Portal Reference: PP-10202800

Application: Application under Section 73 of the Town and Country Planning Act:
Proposed B1 offices and light industrial units and associated parking - Variation of Condition 2 (Approved Plans & Documents) of planning permission DC/18/03811 to allow alterations to the internal layout and appearance of Block H-L and Block D-G (originally approved under planning permission n 2638/15)

Site: Elm Farm Park, Great Green, Thurston, Bury St Edmunds Suffolk IP31 3SH

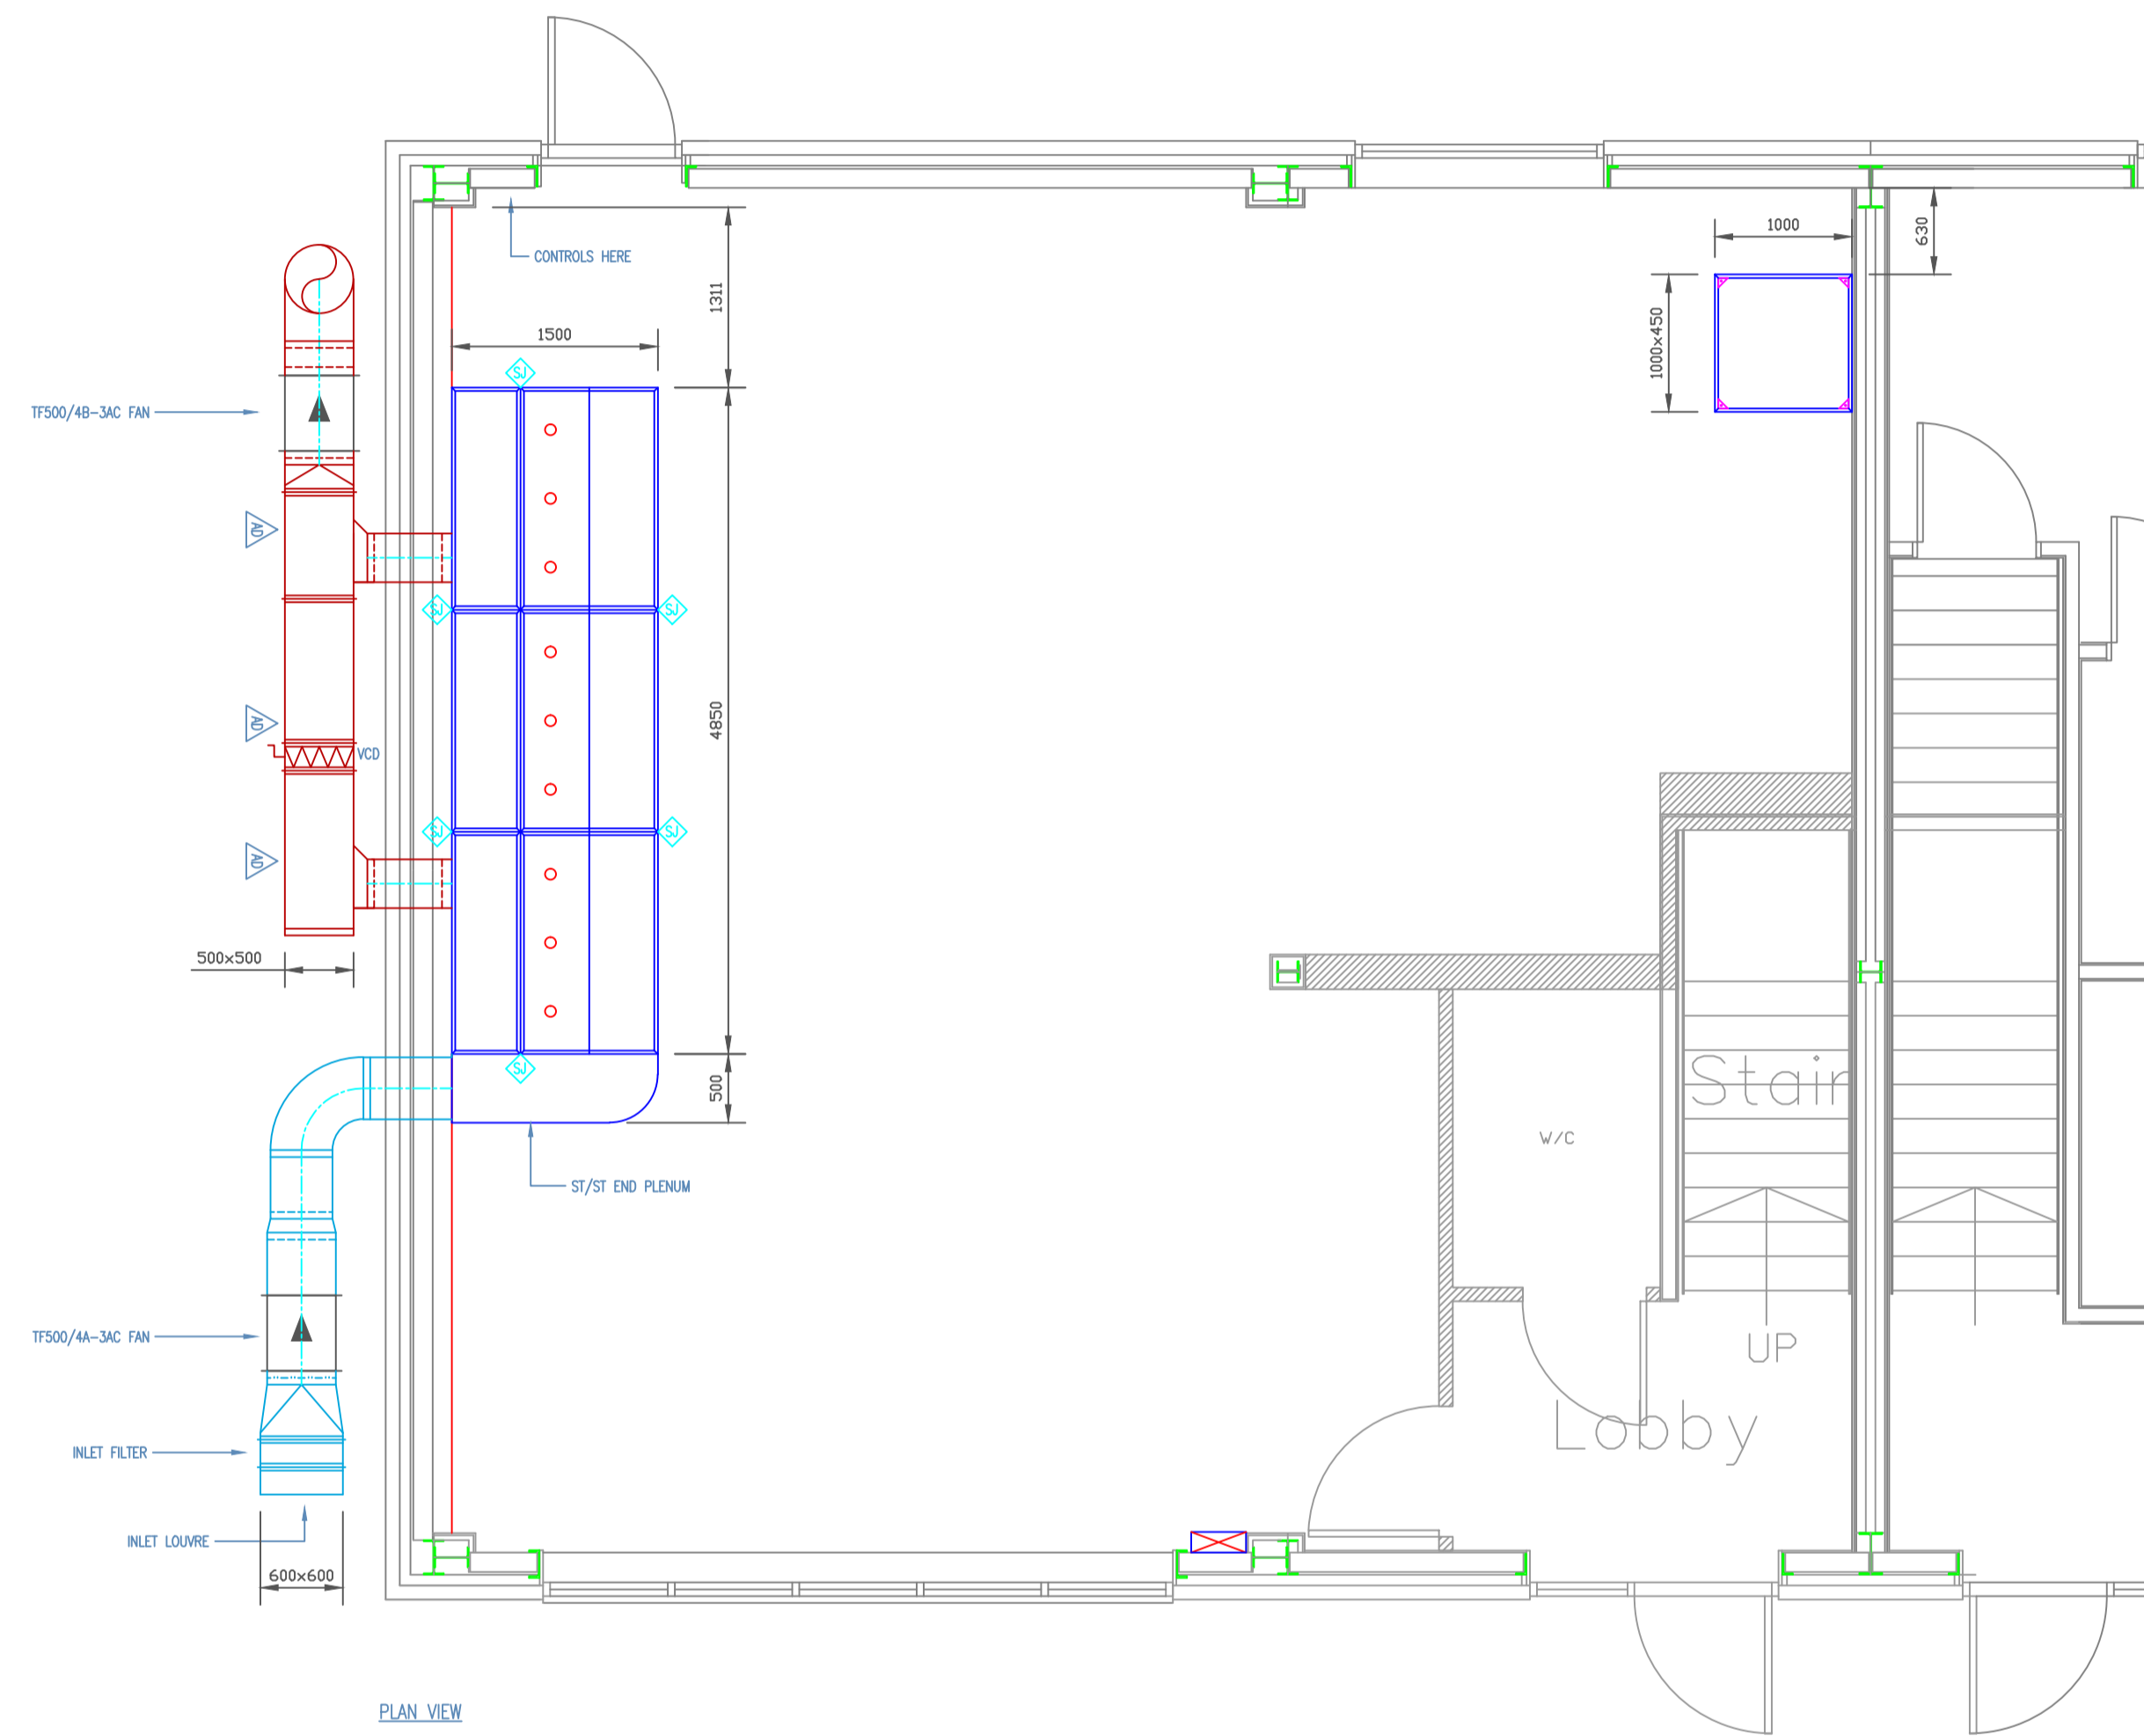
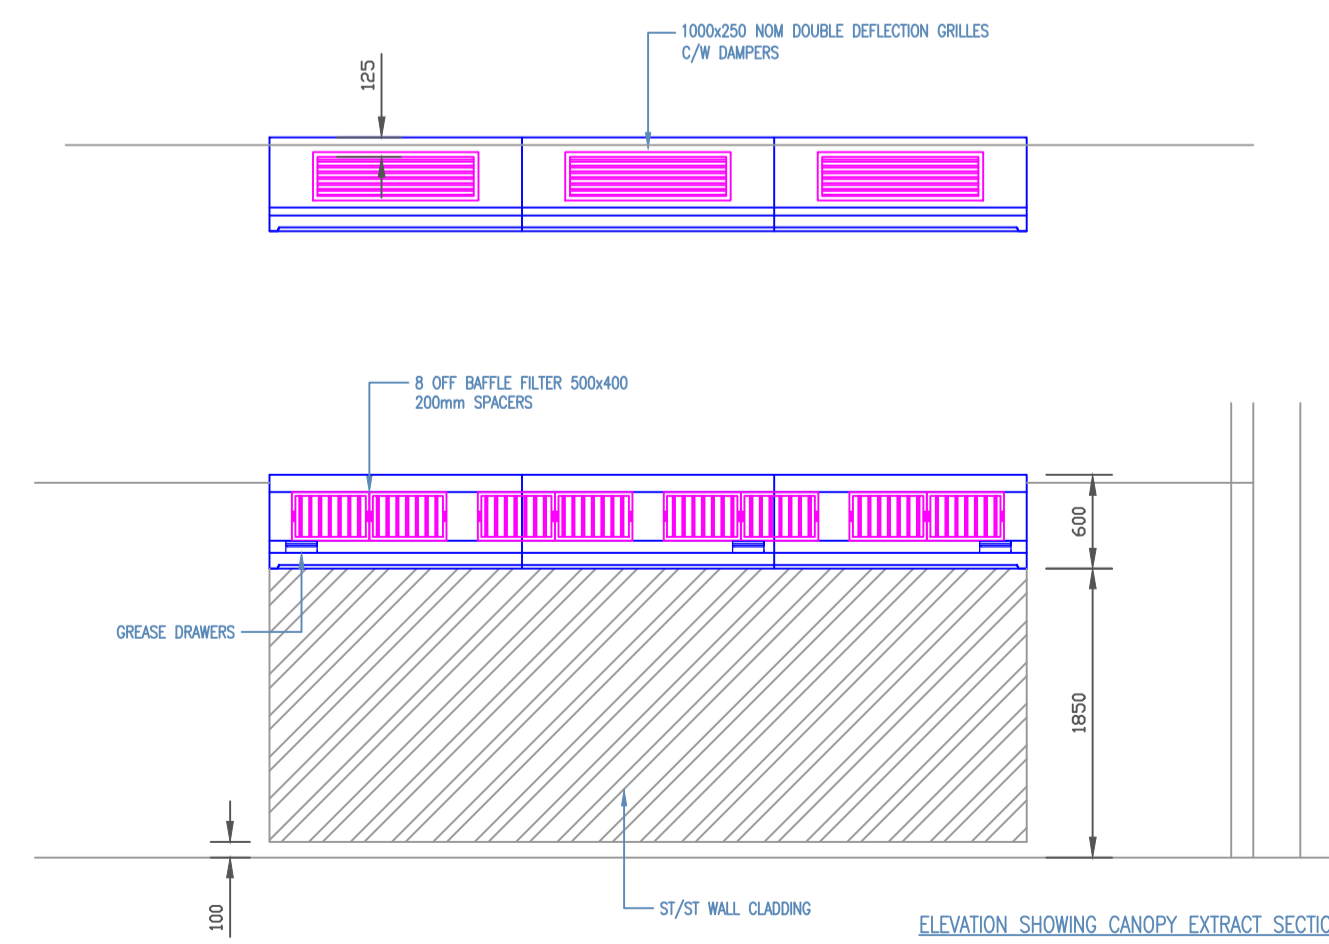
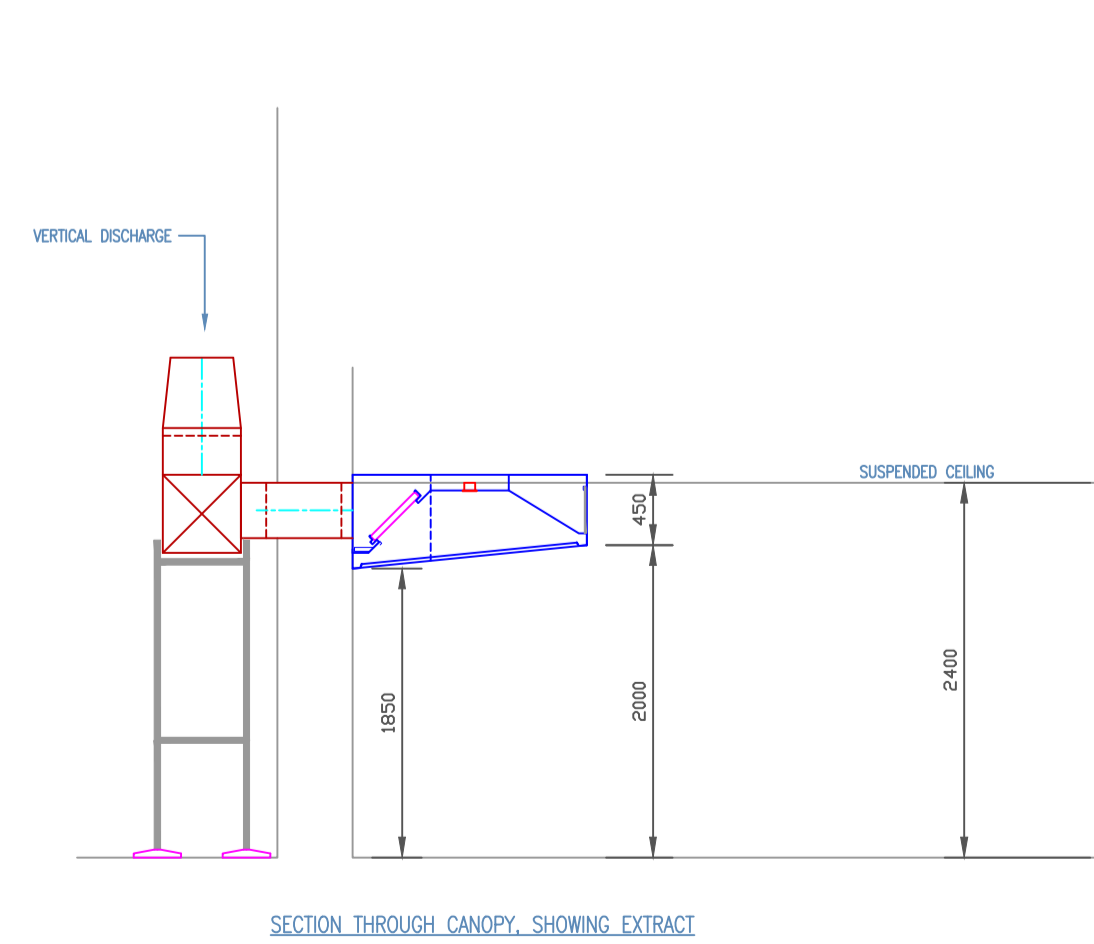
Plans and Elevations (A-C) Drawing number 02 Rev. A	/	No change
Plans and Elevations (D-G) Drawing number 03 Rev. A	Floor Plans Units D-G Drawing Number 4620-10 Rev P8 Elevations Units D-G Drawing Number 4620-11 Rev P3	Enlarged, accessible WCs Unit F – reduced height vehicle access door Unit G – vehicle access door changed to full height windows
Plans and Elevations (H-L) Drawing number 04 Rev. A	Floor Plans Units H-L Drawing Number 4620-20 Rev C9 Elevations Units H-L Drawing Number 4620-21 Rev C4	Position / layout of office accommodation amended Enlarged, accessible WCs Unit H – Installation of commercial kitchen and extraction Units H - L – vehicle access doors changed to full height windows or reduced in height and re-positioned to account for new internal layout
Tree Protection Plan & Landscape Proposal	/	No change
/	Unit H - Ventilation Details Drawing Number NWV8398/1	Additional plan showing extraction system and external flue details
